**Re: Aloft Hotel at 1515 Aircraft Ave. SE
Erosion and Sediment Control Plan – M15E057 – (SWQ-2025-00060)
Engineer's Stamp Date: 10/24/25**

Based on the information in your submittal received on 10/25/25, the ESC Plan can't be approved until the following comments are addressed.

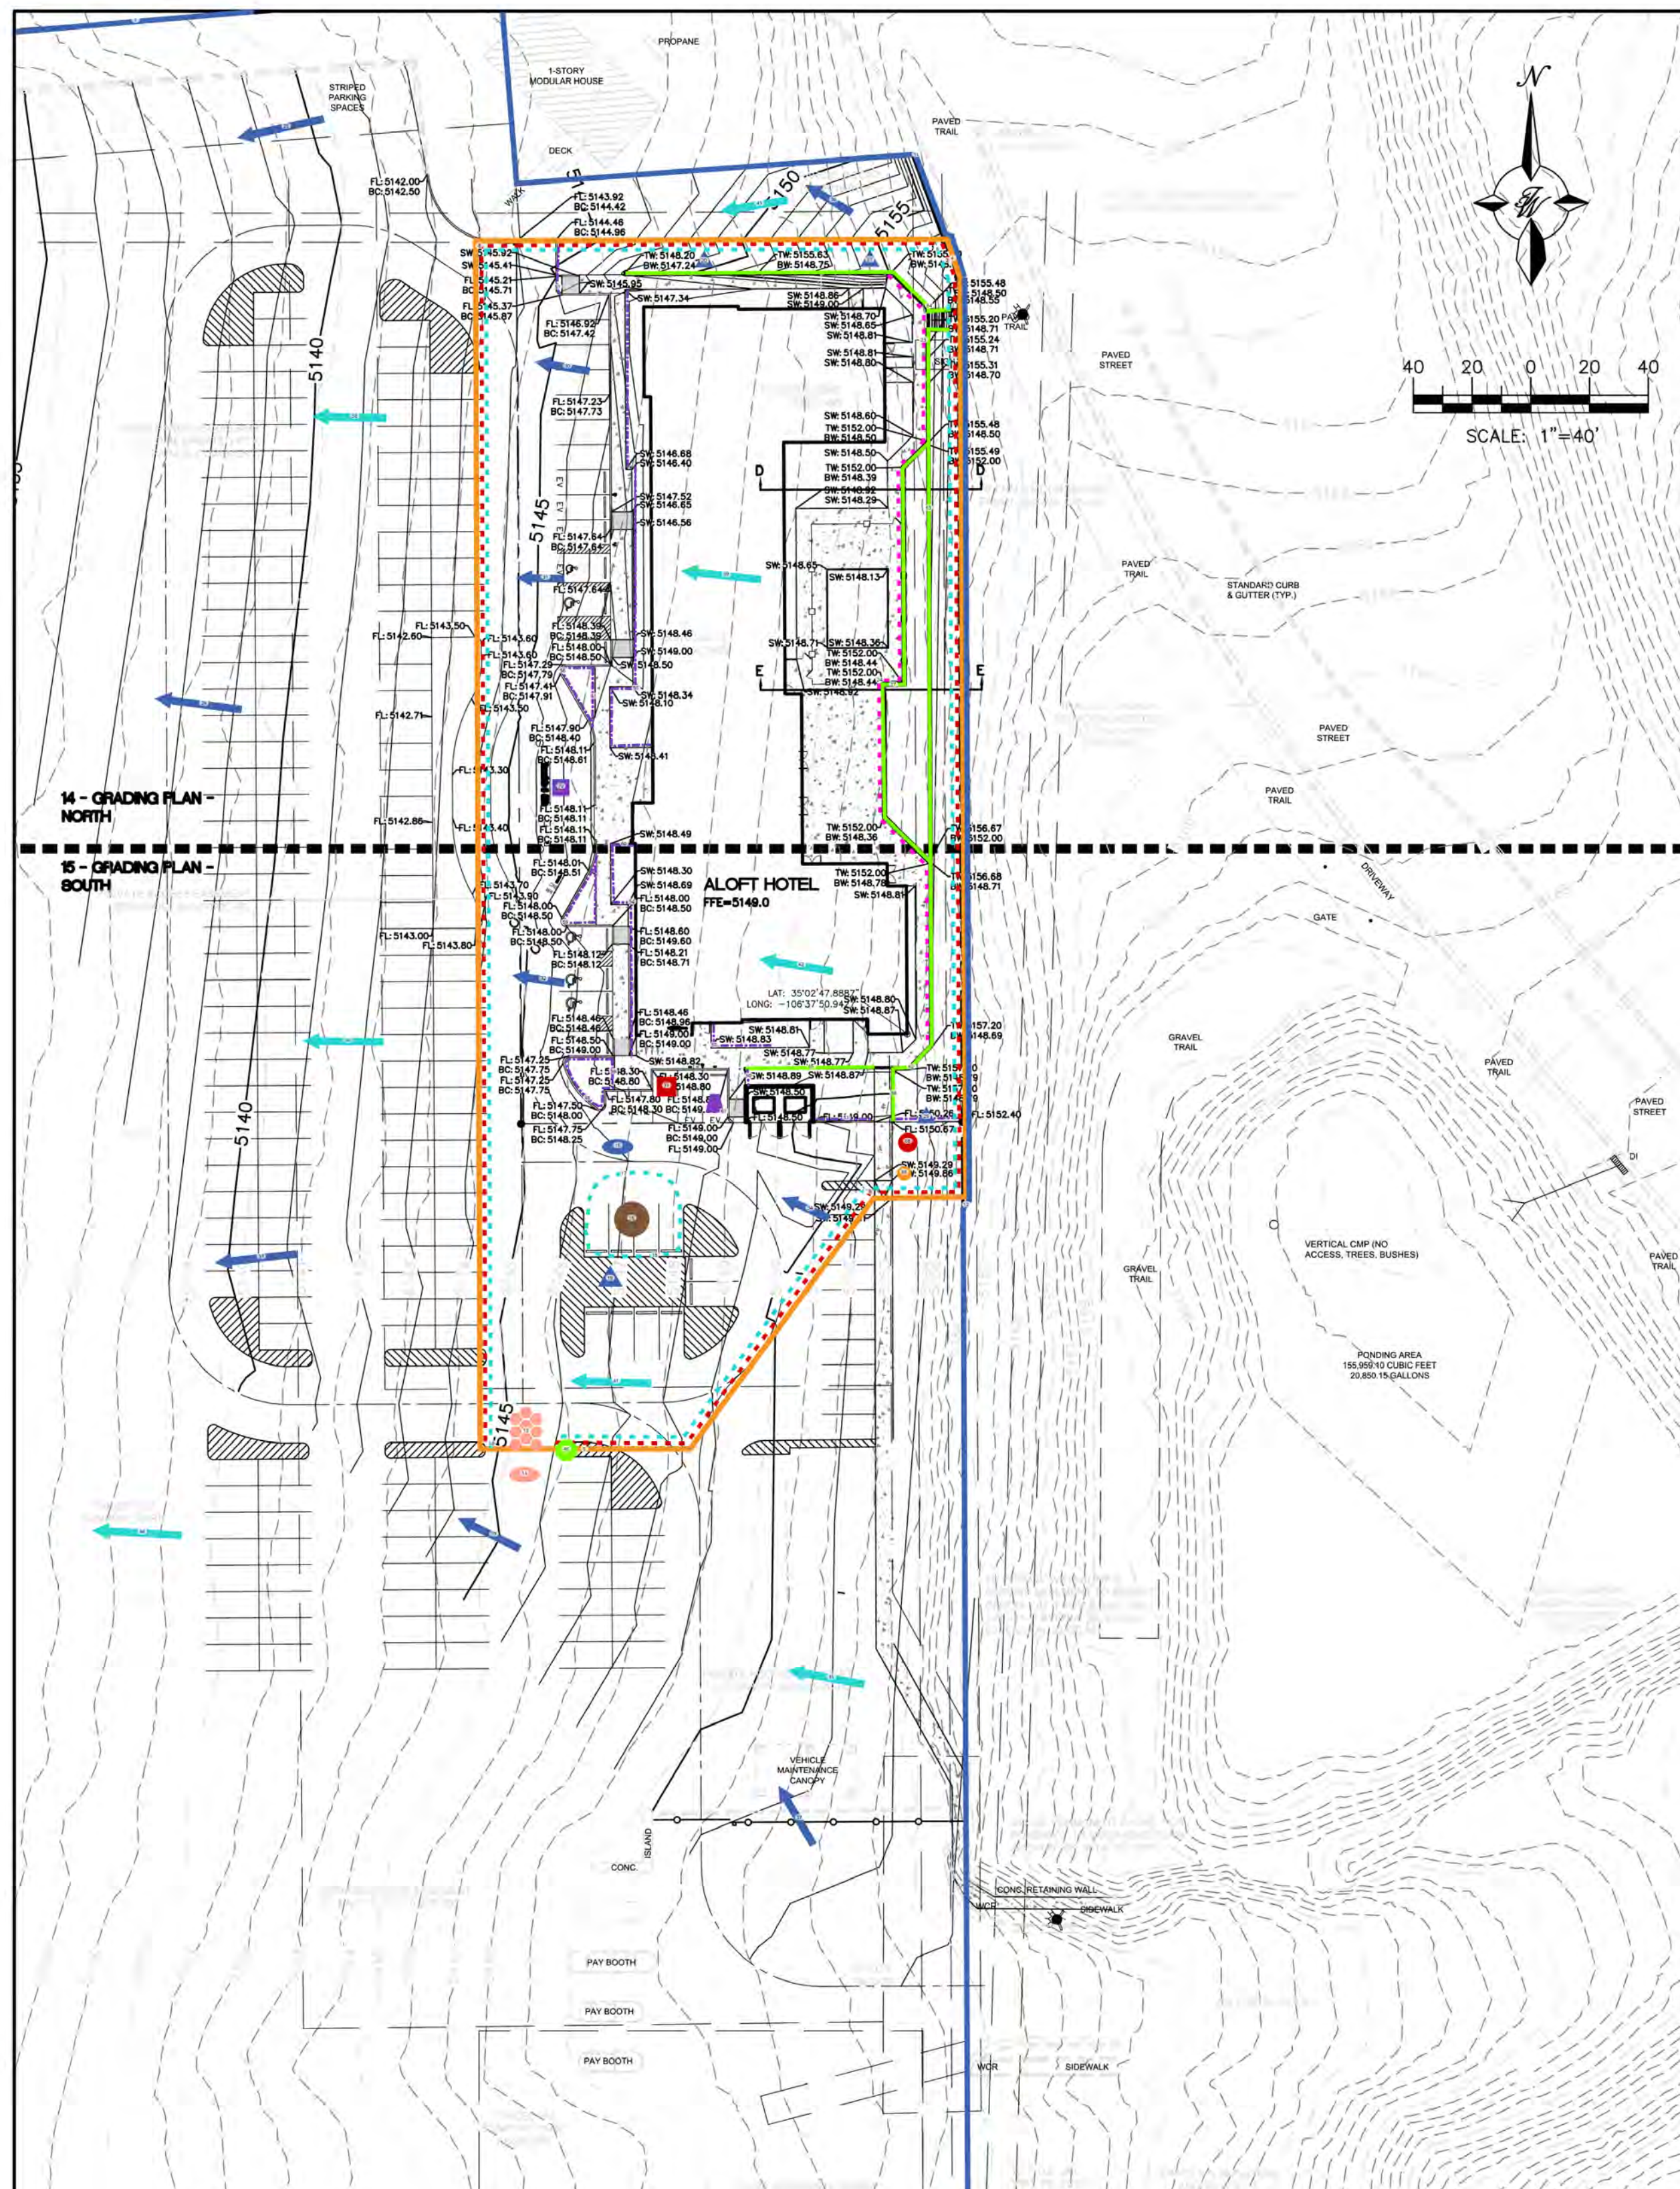
1. The ESC Plan can't be approved until after Hydrology approves the G&D Plan. Hydrology rescinded the G&D approval on 12/10/25, and there is no record of a resubmittal to Hydrology. The existing and proposed grades must be shown on the ESC Plan, and they must agree with the Grading Plan approved by Hydrology per CGP7.2.4.b.ii.

2. The *limits of disturbance* aren't located at the limits of grading as indicated by the proposed contours. Resolve the discrepancy between the contours and the *limits of disturbance*.

3. Show the property lines and easement lines on the ESC Plan. The Easements are the most logical location for the limits of disturbance.
4. I can't distinguish between building, sidewalk, asphalt, and dirt on the ESC Plan. Construction specifications for these structures must be clearly identified in the SWPPP per CGP 7.2.4.b.vi. The same information is required in the ESC Application. You may attach a copy of the Site Plan to both the SWPPP and the ESC Application to meet this requirement. Clearly identify the limits of pavement removal and replacement.

Commercial SWPPP map - West end parking lot

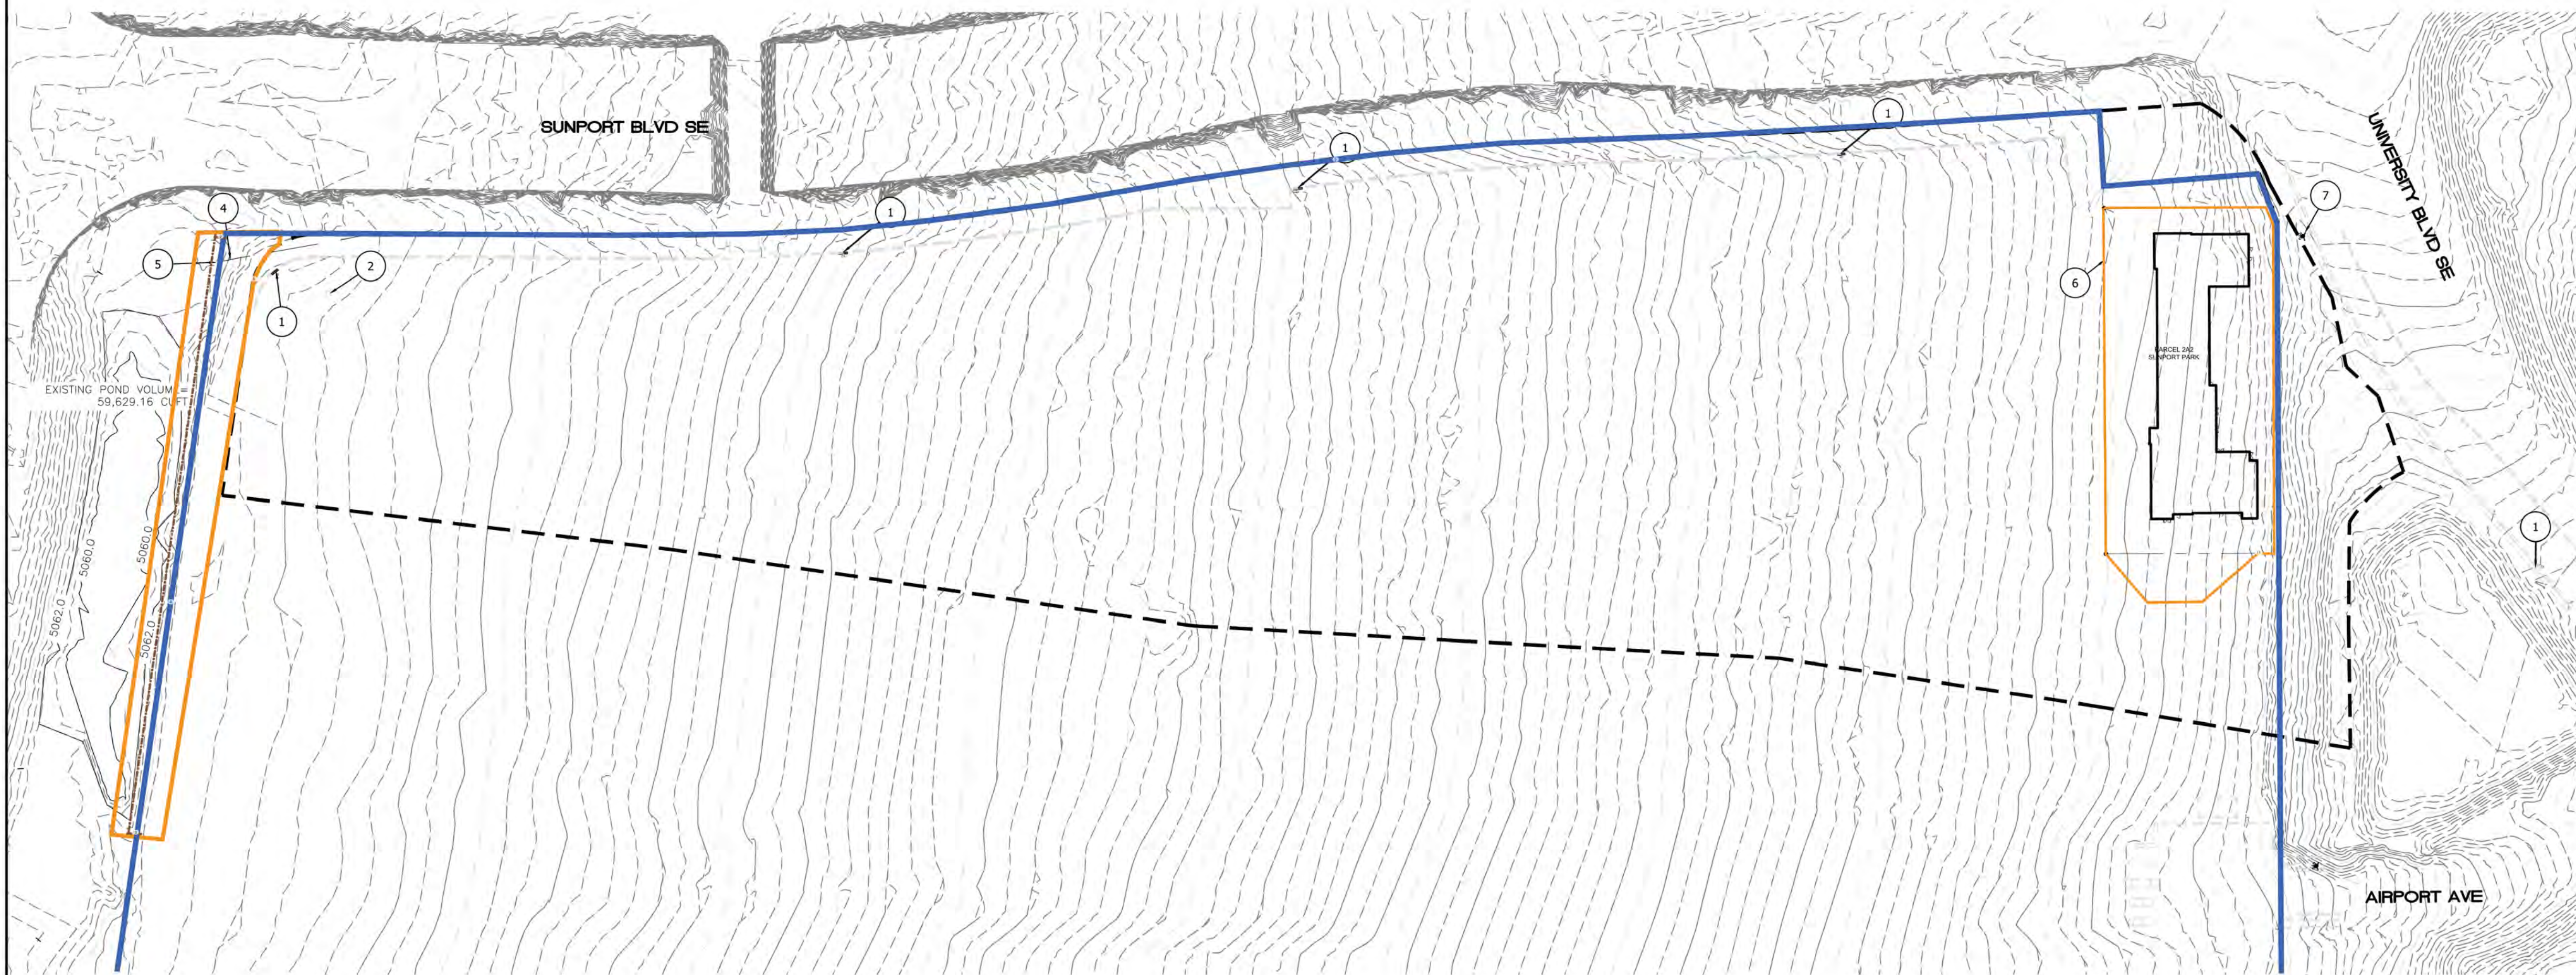
5. The berm at the west edge of the long-term parking has a 16-acre drainage area, which requires a 1.3-acre-foot temporary sediment trap. This is a poor location for BMPs because there is so much undisturbed area. BMPs must be sized for the entire area draining to them, not just the disturbed portion. If all temporary BMPs are moved to the downstream edge of the land-disturbing activities, then sheets 6 and 7 can be deleted. If you leave the temporary BMPs the west edge of the long-term parking, then provide a detailed plan showing the existing drainage patterns there and make sure that the proposed BMPs are sized for the entire area draining to them and ensure they don't interfere with the approved permanent drainage patterns.
